Final Report - Corrections Required **Application No. ANEX-24-0002**

Description : Matrix Design Group on behalf of Colorado Springs Equities LLC is submitting a serial annexation petition for seven parcels and Land Use Plan/Rezoning exhibit for a portion of the subdivision known as Rock Creek Mesa.

Document Filename : 224.023-SURV-RCM ANNEX PLAT 2.pdf

# ANNEXATION PLAT ROCK CREEK MESA ADDITION NO. 2

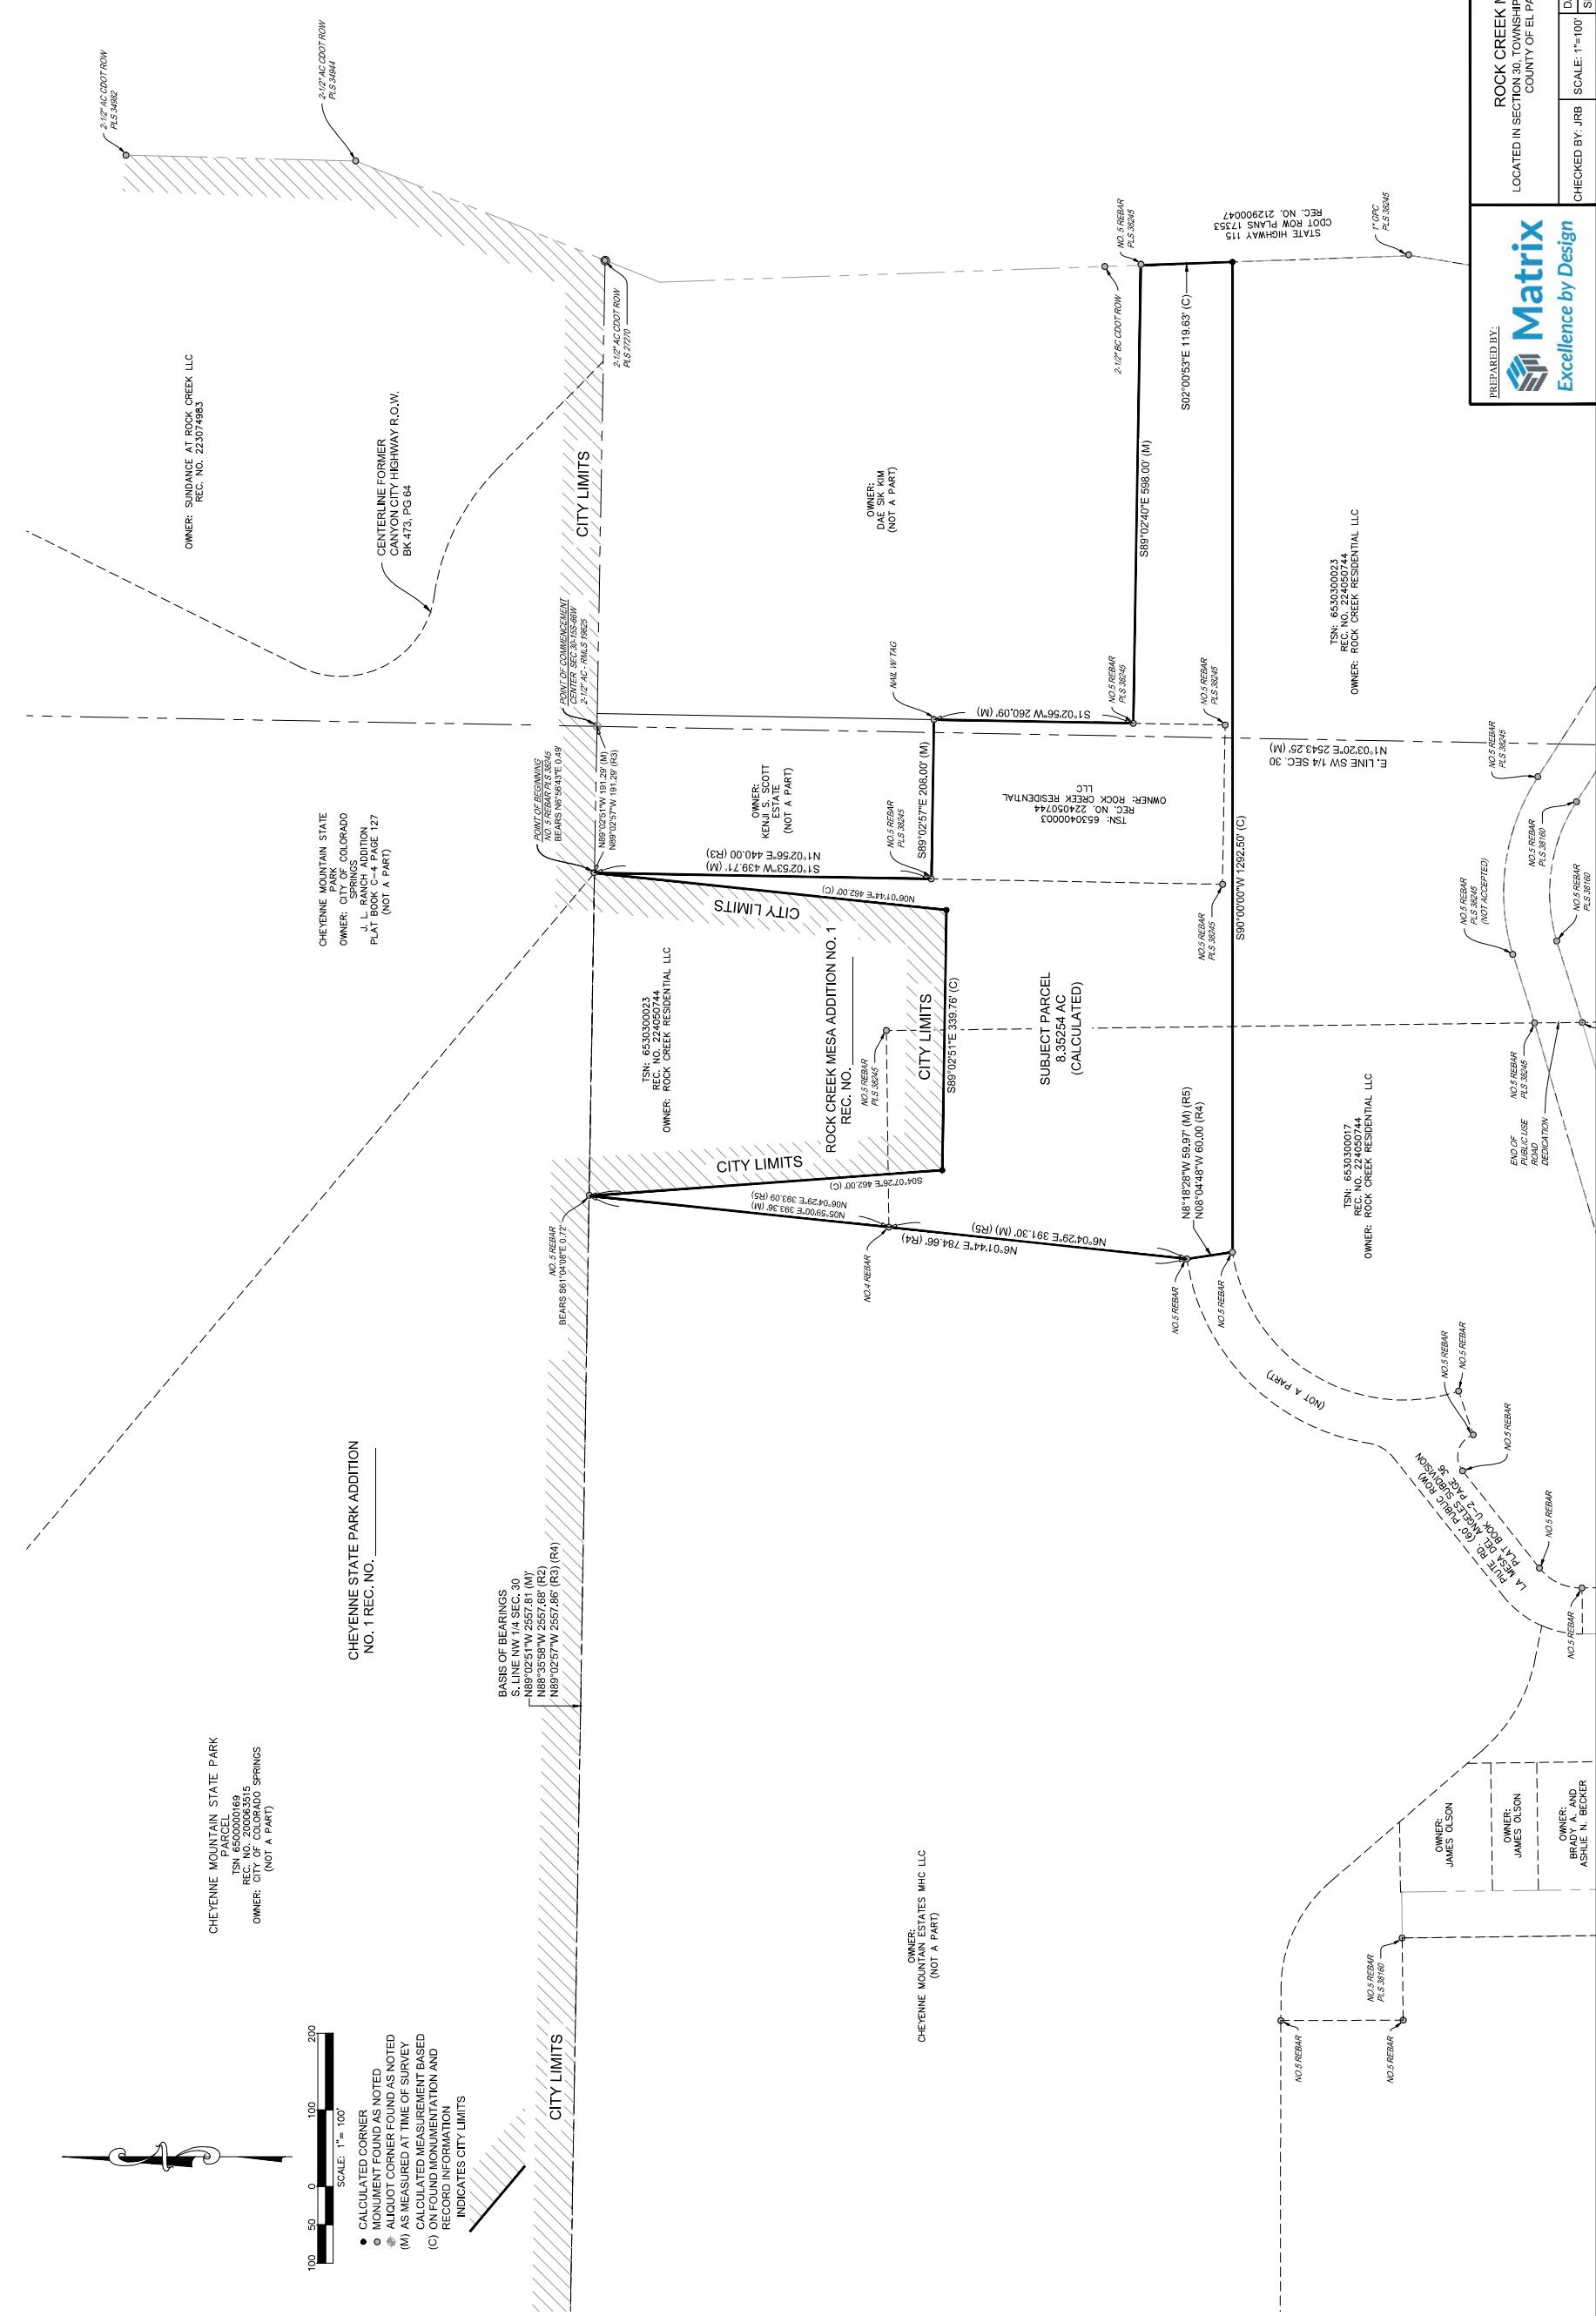
| Comment ID | Page Reference | Reviewer : Department | Review Comments |
|------------|---|-----------------------|--|
| 17 | 224.023-SURV-RCM ANNEX PLAT 2-GRAPHIC 1 | Cory Sharp : Planning | Please clearly depict all of the City Limits, not just that 421' section |
| 18 | 224.023-SURV-RCM ANNEX PLAT 2-GRAPHIC 1 | Cory Sharp : Planning | Please label what this line represents |
| 19 | 224.023-SURV-RCM ANNEX PLAT 2-GRAPHIC 1 | Cory Sharp : Planning | Please add a label for Rock Creek Mesa Addition No. 1 reception No. _____ |
| 20 | 224.023-SURV-RCM ANNEX PLAT 2-GRAPHIC 1 | Cory Sharp : Planning | Please remove the areas from all the adjacent parcels |
| 21 | 224.023-SURV-RCM ANNEX PLAT 2-GRAPHIC 1 | Cory Sharp : Planning | It would be easier to review if the adjacent areas were dashed line types instead of solid line types, please review and adjust accordingly. |
| 22 | 224.023-SURV-RCM ANNEX PLAT 2-GRAPHIC 1 | Cory Sharp : Planning | Please clearly label the adjacent areas *not a part* for clarity |
